Consultation Response from: KC Environmental Health (Pollution & Noise Control)
2023/92034 - adj, 655, Halifax Road, Hightown, Liversedge, WF15 8HE
Discharge condition 4 (parking), 6 (materials), 8 (Phase I Desk Study Report), 9 and 10 Phase II Intrusive Site Investigation Report, 13 (charging electric vehicles), 16 (drainage) on previous permission 2019/93380 for erection of detached dwelling with associated parking and amenity space
Date Responded:
3rd August 2023
Responding Officer:
NH
Responding Ref:
WK/202321401

Condition 13 – Electric Vehicle Charging Point (EVCP)

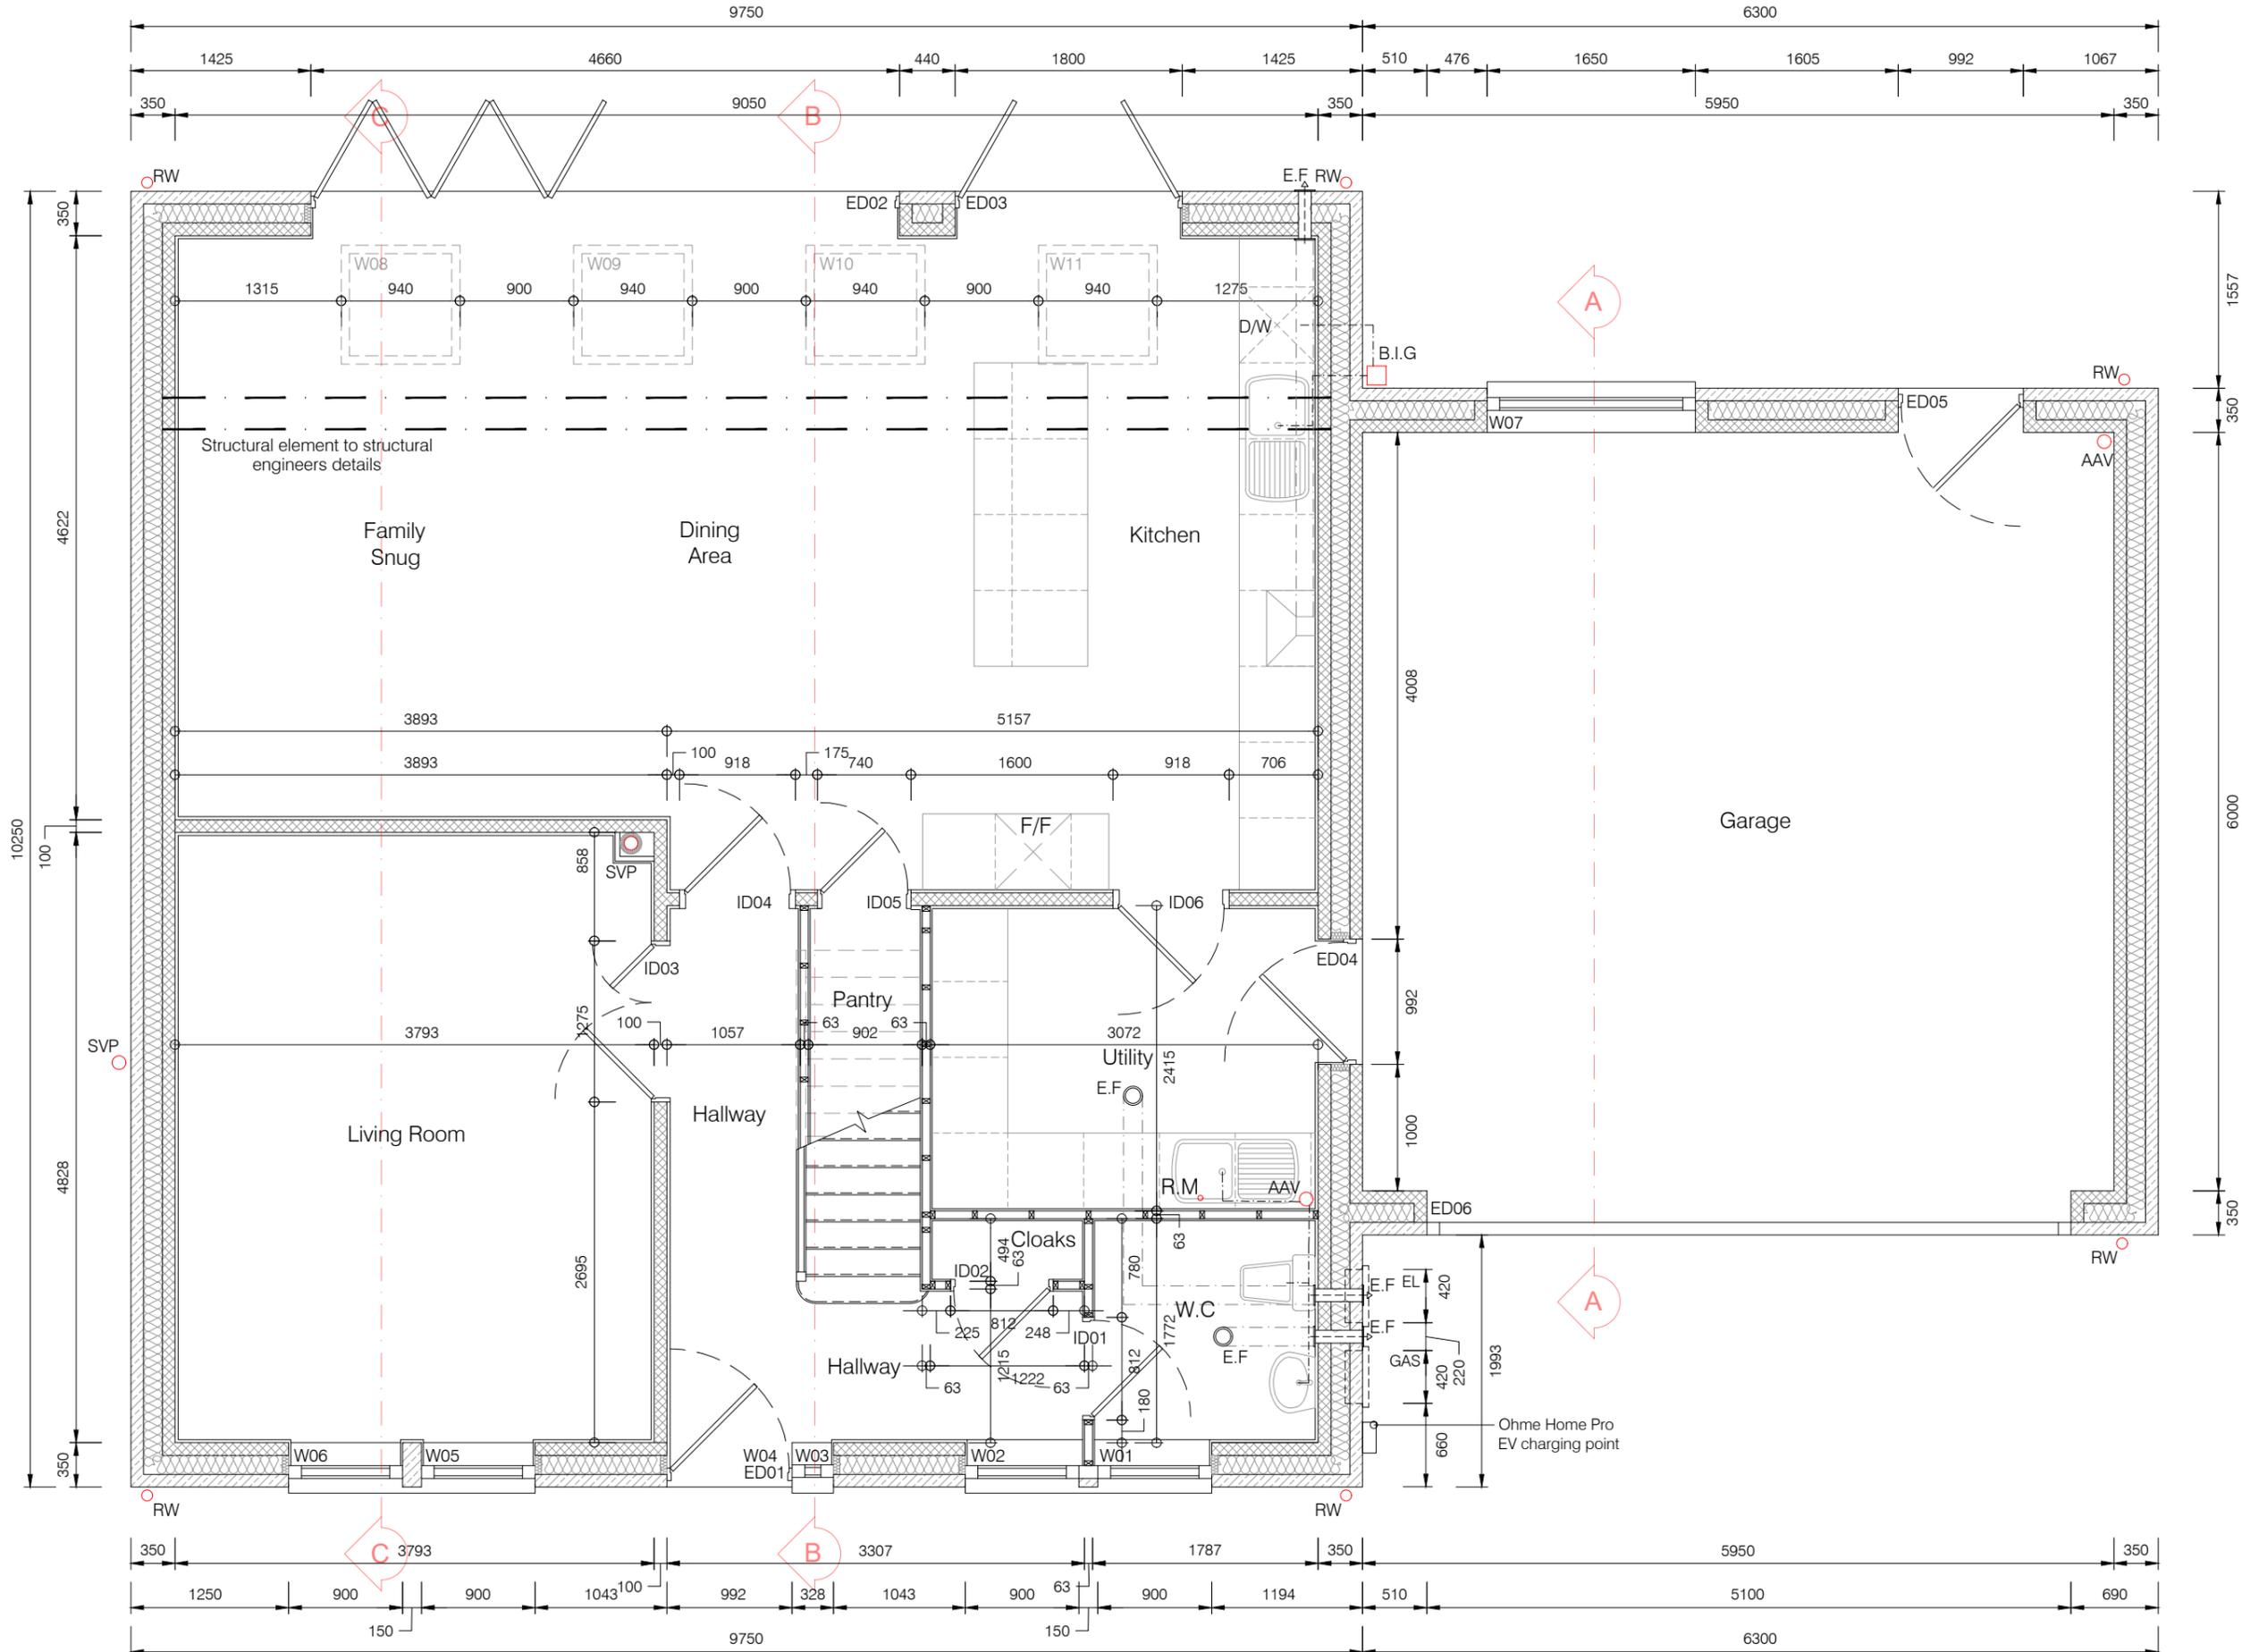
A Proposed Ground Floor Setting Out Plan by Studio 91 Architecture dated April 2023 (Drawing no. BR-201) has been received in support of Condition 13. The plan shows the proposed installation of a Ohme Home Pro EV charging point.

The supporting documents do not appear to include a technical specification for the proposed EVCP. Therefore, it is unclear whether the EVCP will meet the requirements of the condition. To wholly fulfil the requirements of Condition 13, the applicant needs to provide the Local Planning Authority (LPA) evidence that the proposed EVCP unit will meet the conditions prescribed minimum technical requirements. Once the LPA has received satisfactory technical information, Condition 13 should not be discharged until the EVCP is installed and made operational.

We acknowledge the information provided however we require additional information to wholly satisfy the requirements of the condition. Therefore Condition 13 must remain until further notice.
